**EL PASO COUNTY PLANNING AND
 COMMUNITY DEVELOPMENT
 DEPARTMENT**

GRADING AND EROSION CONTROL PLAN CHECKLIST

Revised: July 2019

LORSON RANCH
CREEKSIDE DEVELOPMENT
EAST FORK JIMMY CAMP CREEK
GRADING AND EROSION CONTROL PLAN
EL PASO COUNTY, COLORADO

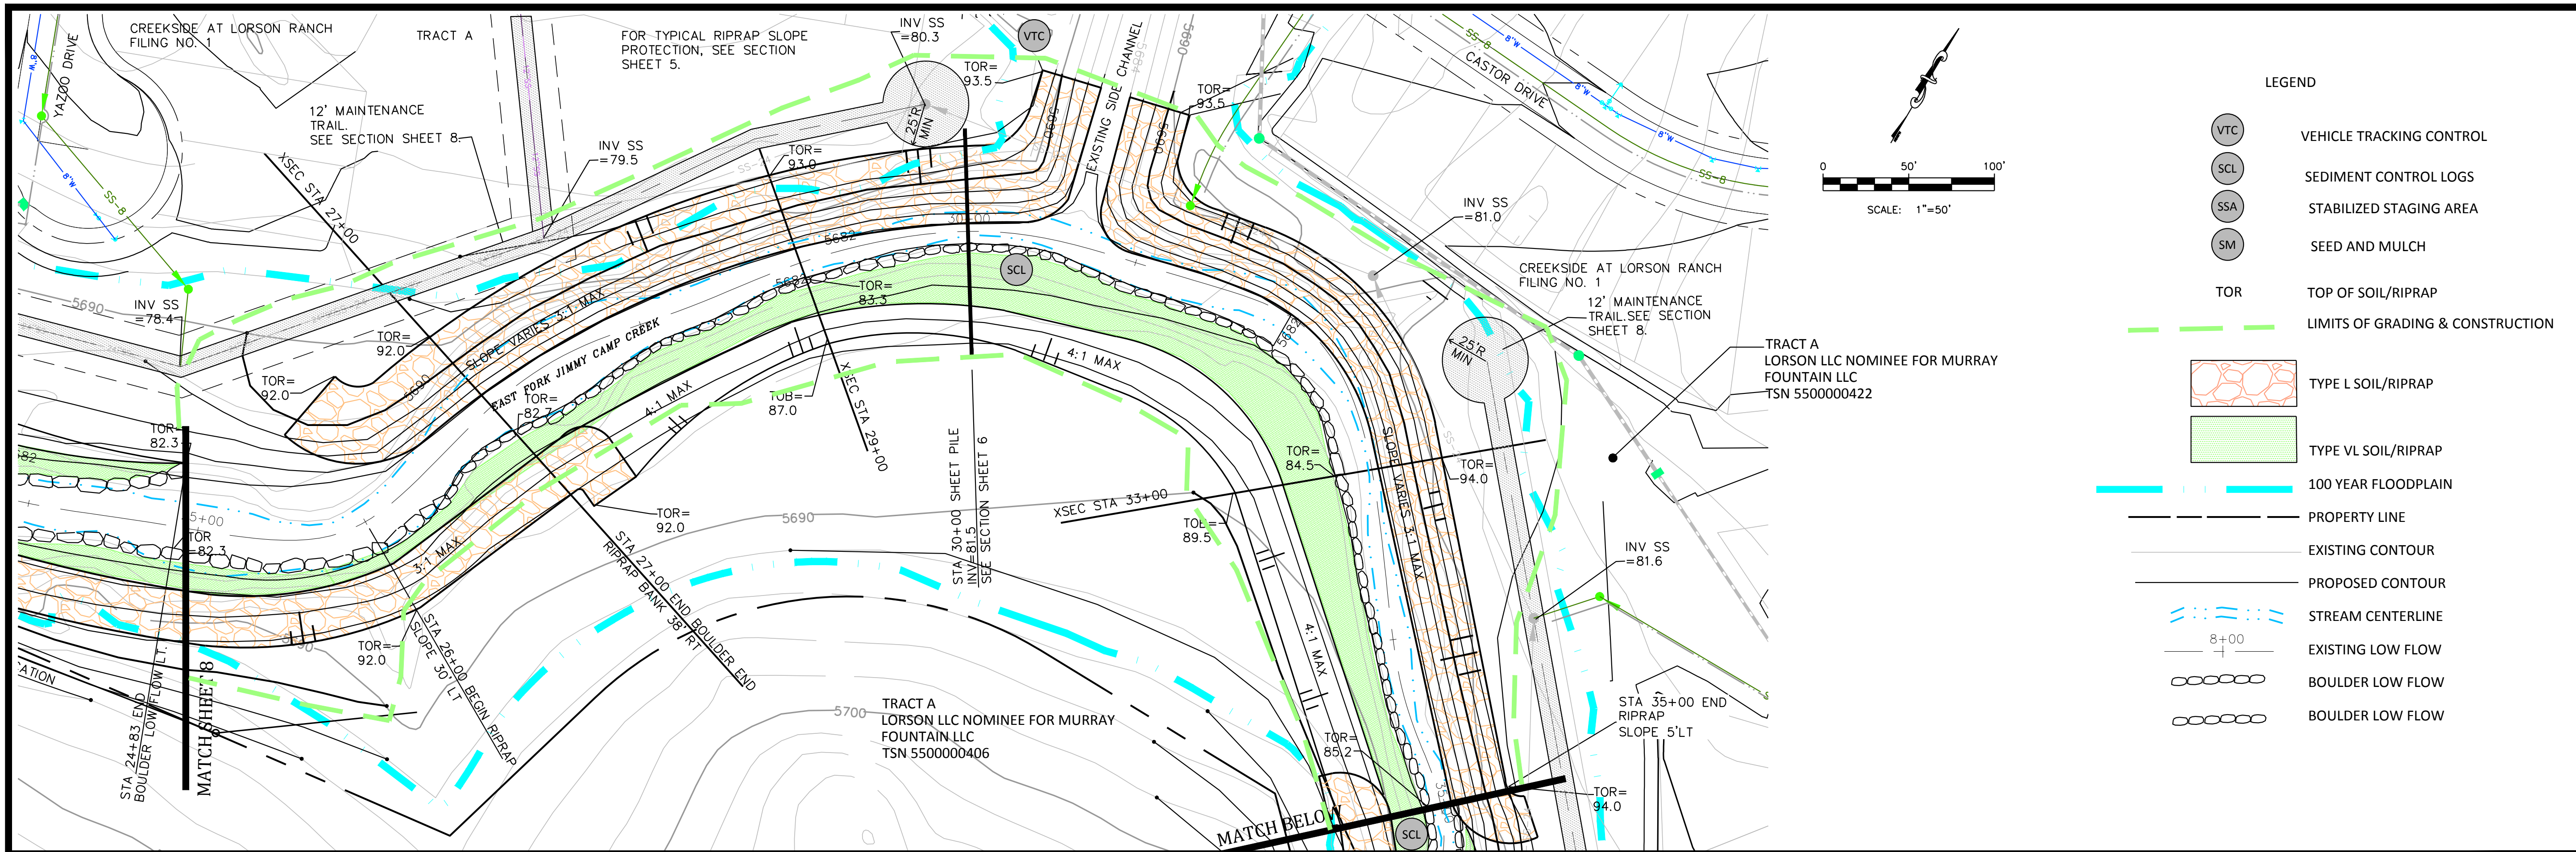
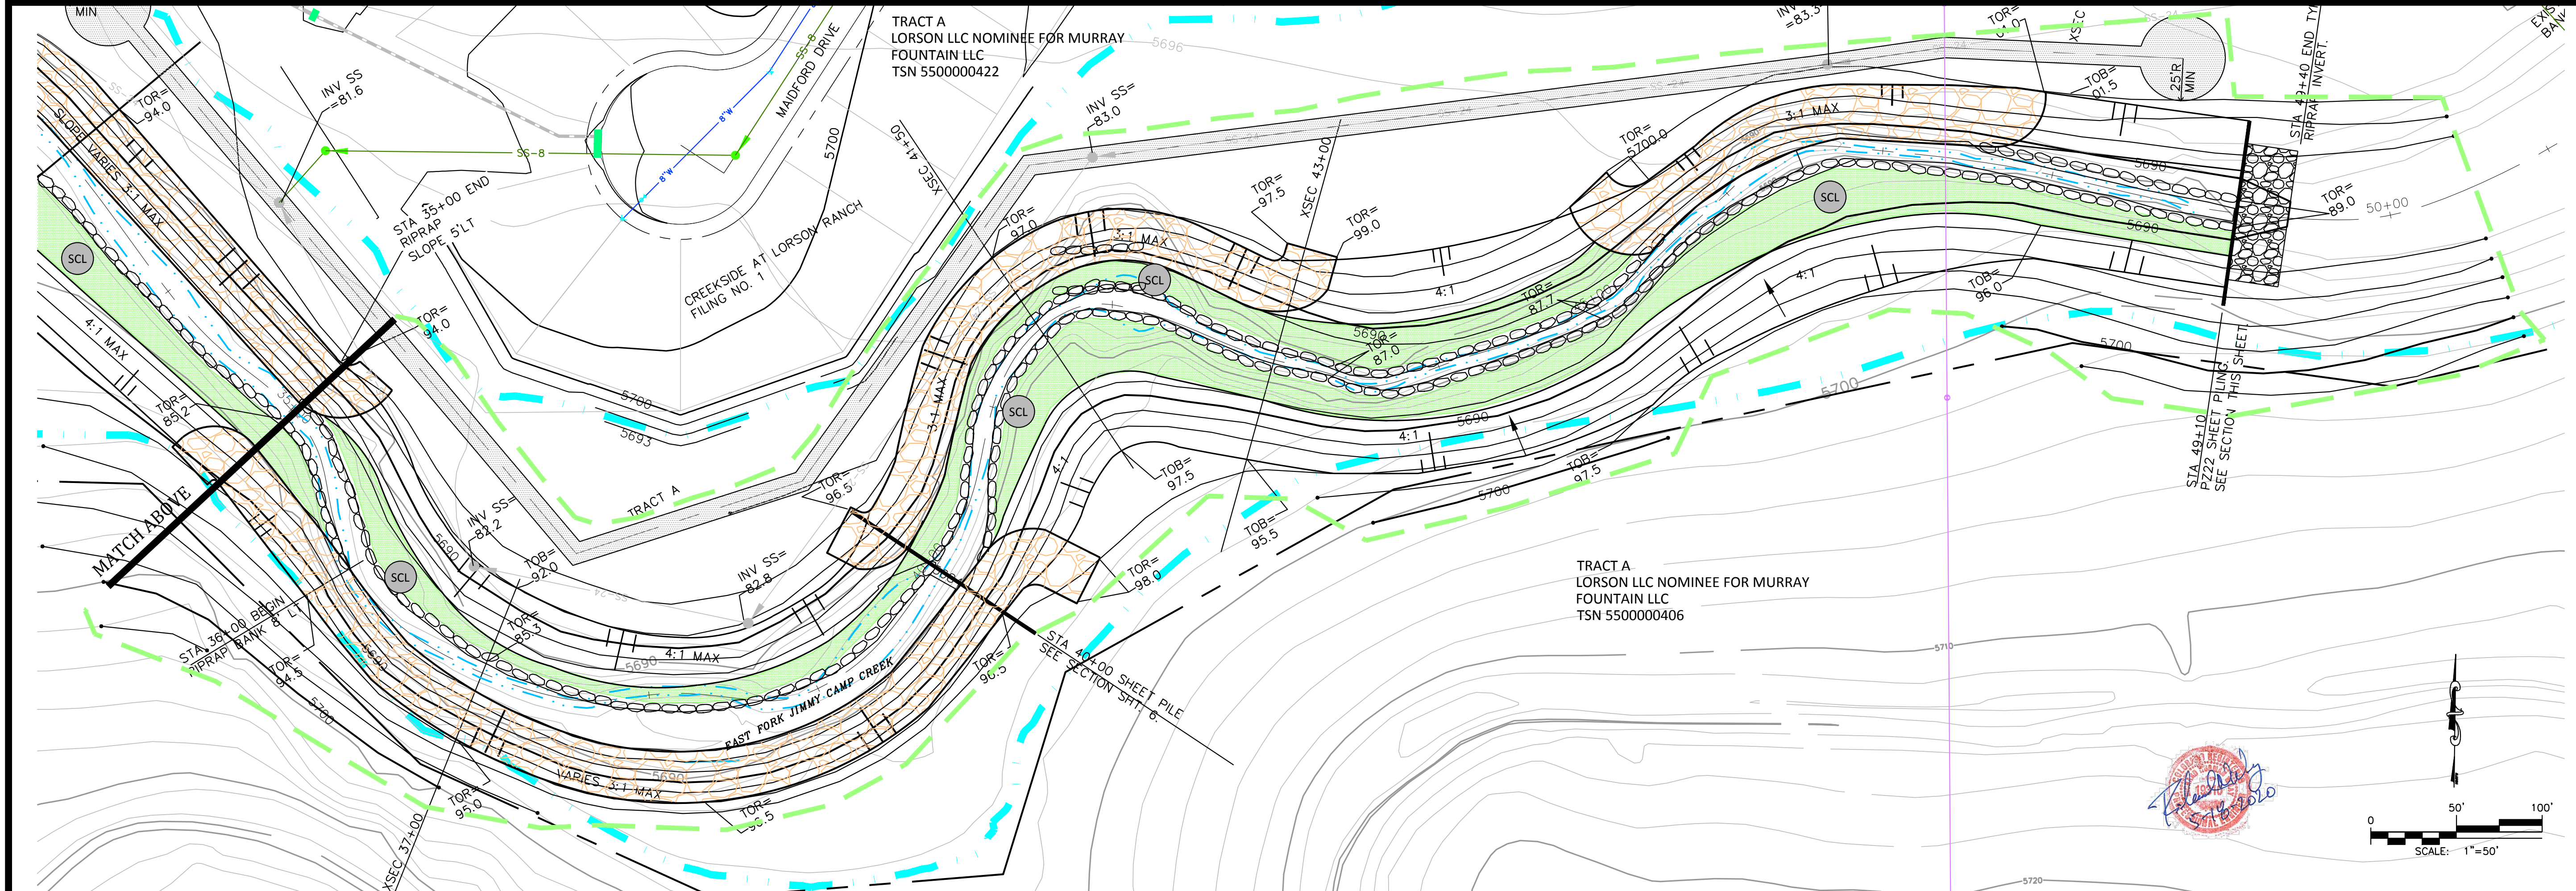
Applicant	PCD
1. GRADING AND EROSION CONTROL PLAN			
a	Vicinity map.	X	✓
b	Adjacent city/town/jurisdictional boundaries, subdivision names, and property parcel numbers labeled.	X	✓
c	North arrow and acceptable scale (1"=20' to 1"=100').	X	✓
d	Legend for all symbols used in the plan. show all symbols in the legend	X	✗
e	Existing and proposed property lines. Proposed subdivision boundary for subdivision projects.	X	✓
f	All existing structures.	X	✓
g	All existing utilities.	X	✓
h	Construction site boundaries.	X	✓
i	Existing vegetation (notes are acceptable in cases where there is no notable vegetation, only grasses/weeds, or site has already been stripped).	X	✓
j	FEMA 100-yr floodplain.	X	✓
k	Existing and proposed water courses including springs, streams, wetlands, detention ponds, stormwater quality structures, roadside ditches, irrigation ditches and other water surfaces. Show maintenance of pre-existing vegetation within 50 feet of a receiving water.	X	✓

v	All proposed temporary construction control measures, structural and non-structural. Temporary construction control measures shall be identified by phase of implementation to include "initial," "interim," and "final" or shown on separate phased maps identifying each phase.	X	✓
w	Vehicle tracking provided at all construction entrances/exits. Construction fencing, barricades, and/or signage provided at access points not to be used for construction.	X	✓
x	Temporary sediment ponds provided for disturbed drainage areas greater than 1 acre.	X	✓
y	Dewatering operations to include locations of diversion, pump and discharge(s) as anticipated at time of design.	X	✓
z	All proposed temporary construction control measure details. Custom or other jurisdiction's details used must meet or exceed EPC standards. Add sediment control BMPs and update VTC detail	X	✗
